**City of Albuquerque, NM  
Plan Review**

**RE: Building Plan Check Corrections  
BP-2024-40415  
TA Travel Centers #081  
2501 University Blvd, NE  
Albuquerque, NM 87107**

TA Travel Centers received the following comments regarding the proposed installation of an automated parking gate. The individual comments and replies are provided below.

TT1.0

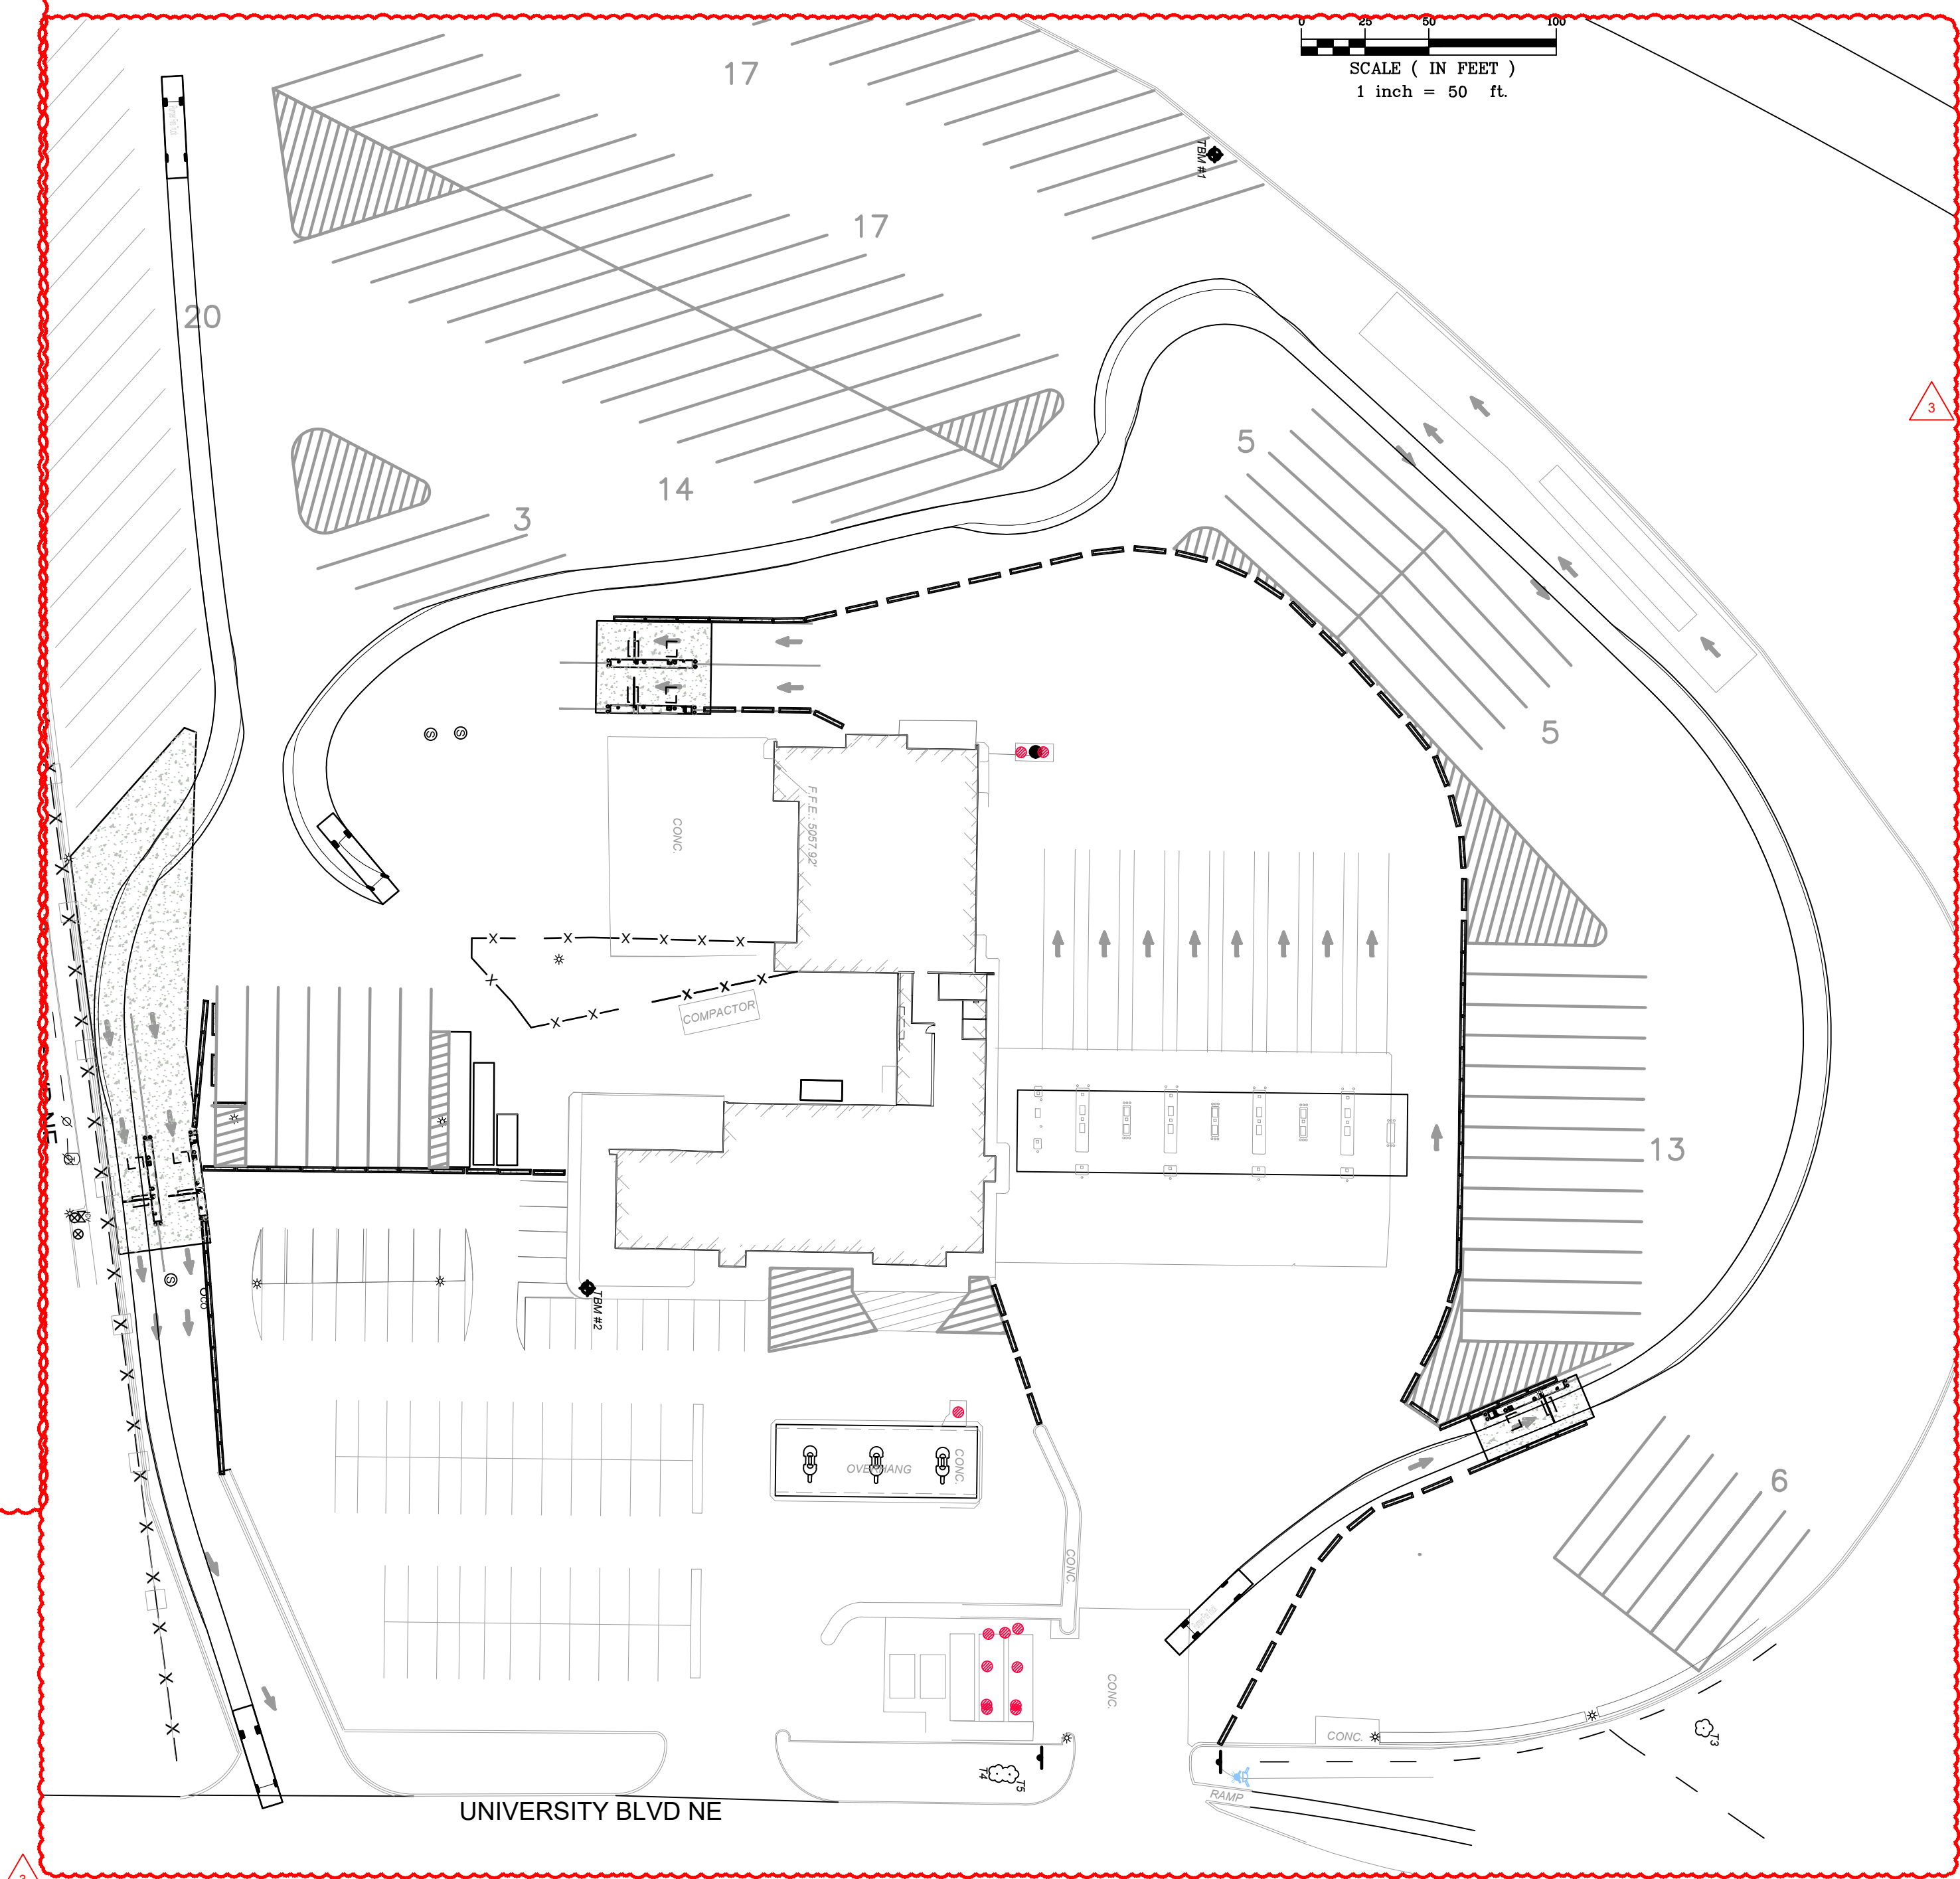
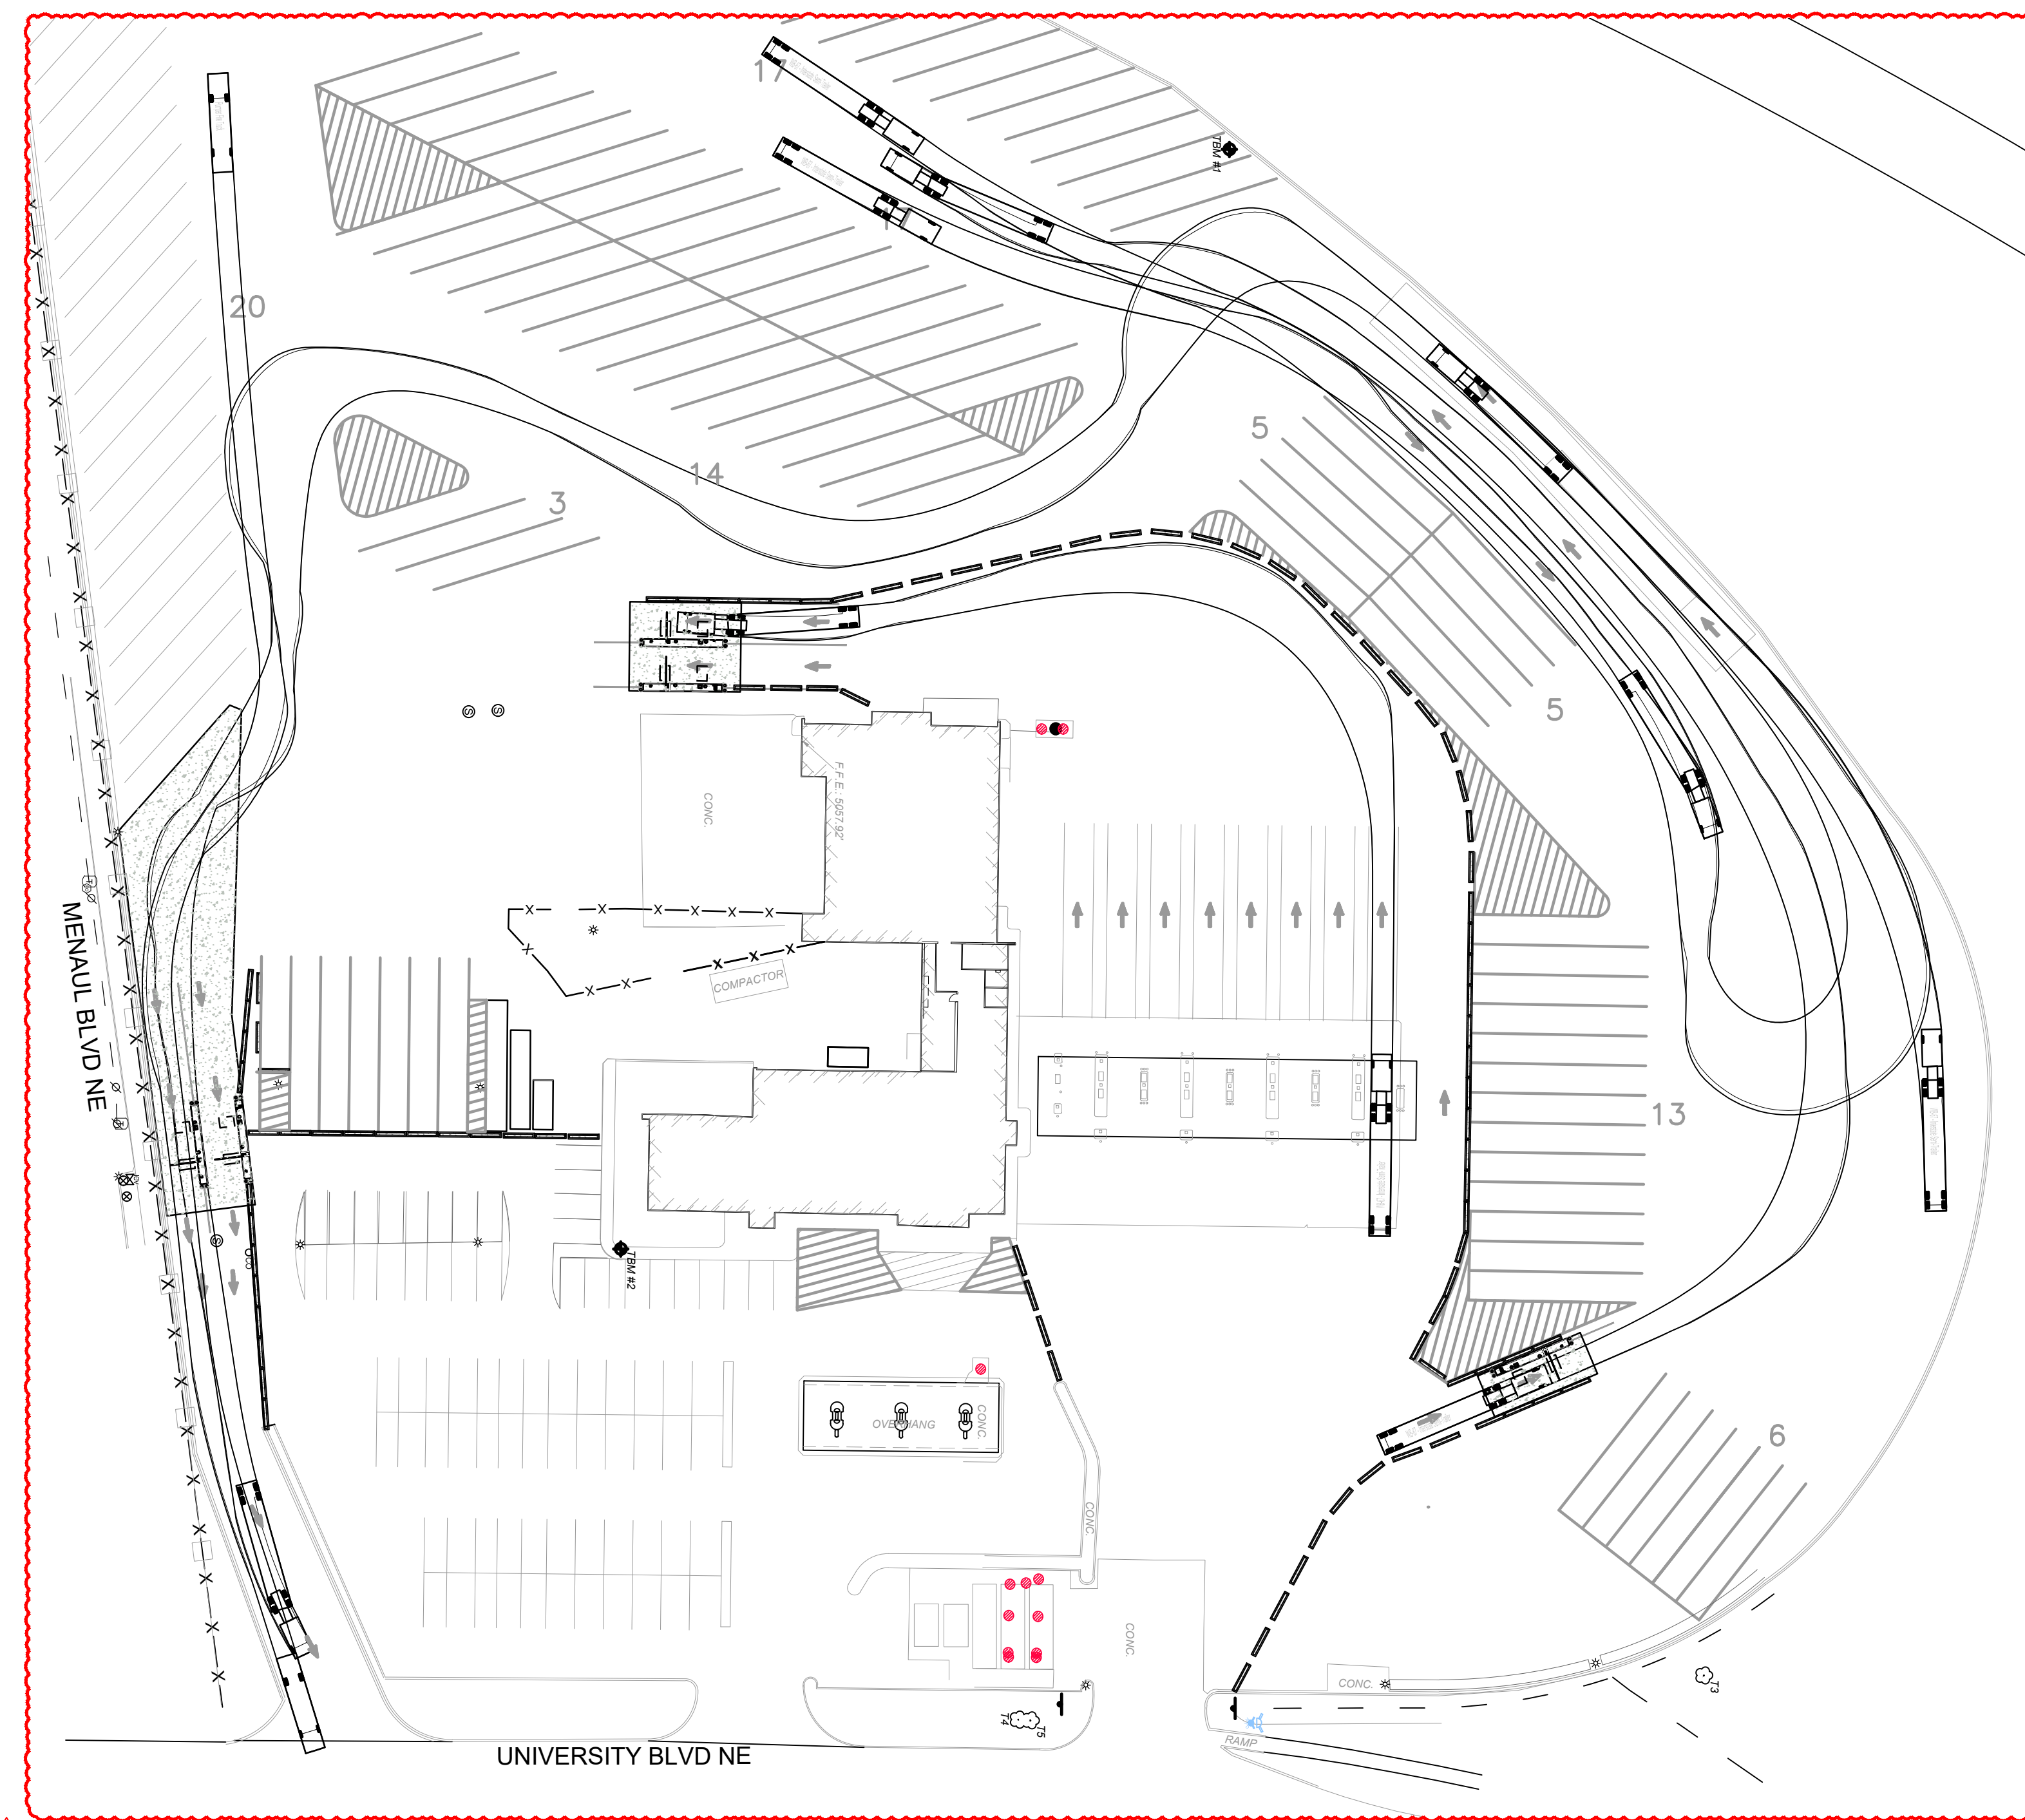
â€¢ A Traffic Circulation Layout (TCL) plan is required, when new or modified changes are requested for site access, circulation for parking areas, and drive through facilities. A pre-design conference with this office is recommended, to schedule a meeting contact: Marwa Al-najjar; 505-924-3675,

\*AFR WOULD LIKE COMPLETE ACCESS FOR APPARATUS. GATE DETAIL LARGE ENOUGH FOR LADDER ACCESS? KNOX KEY SWITCH ON GATES? EXIT DISCHARGE IN BUBBLED ARE NOT COMPLETE, WHERE DOES THIS EXIT LEAD, I.E. MAJOR ROADS.

BUILDING STRUCTURES MUST BE ACCESSIBLE FOR FIRE ATTACK. SHOW FDC CONNECTIONS AND PIV LOCATIONS FOR SPRINKLER SYSTEM ON PLANS. WE MAY NEED TO SUBMIT ANOTHER FIRE 1 SHEET FOR THE NEW TCL LAYOUT FOR THE FIRE MARSHALS FIRE STAMP ON YOUR FULL SET OF PLANS. PLEASE CONTACT THE OFFICE AT 505-924-3611 FOR AN INVITATION TO EPLANS.

- Please find the attached Drawing PDF titled “#081 Parking Gate-TT1.0 Truck Turn Plan” addressing Traffic Circulation Layout comments item Ref.#3.
-

- Please find the attached Drawing PDF titled “#081 Parking Gate-TT1.0 Truck Turn Plan” and “#081 Parking Gate-E1.0 Conduit Plan” showing installation location of Knox box. addressing comments item Ref.#4. Access gates lanes are 14’6” wide allowing emergency vehicle access.
-
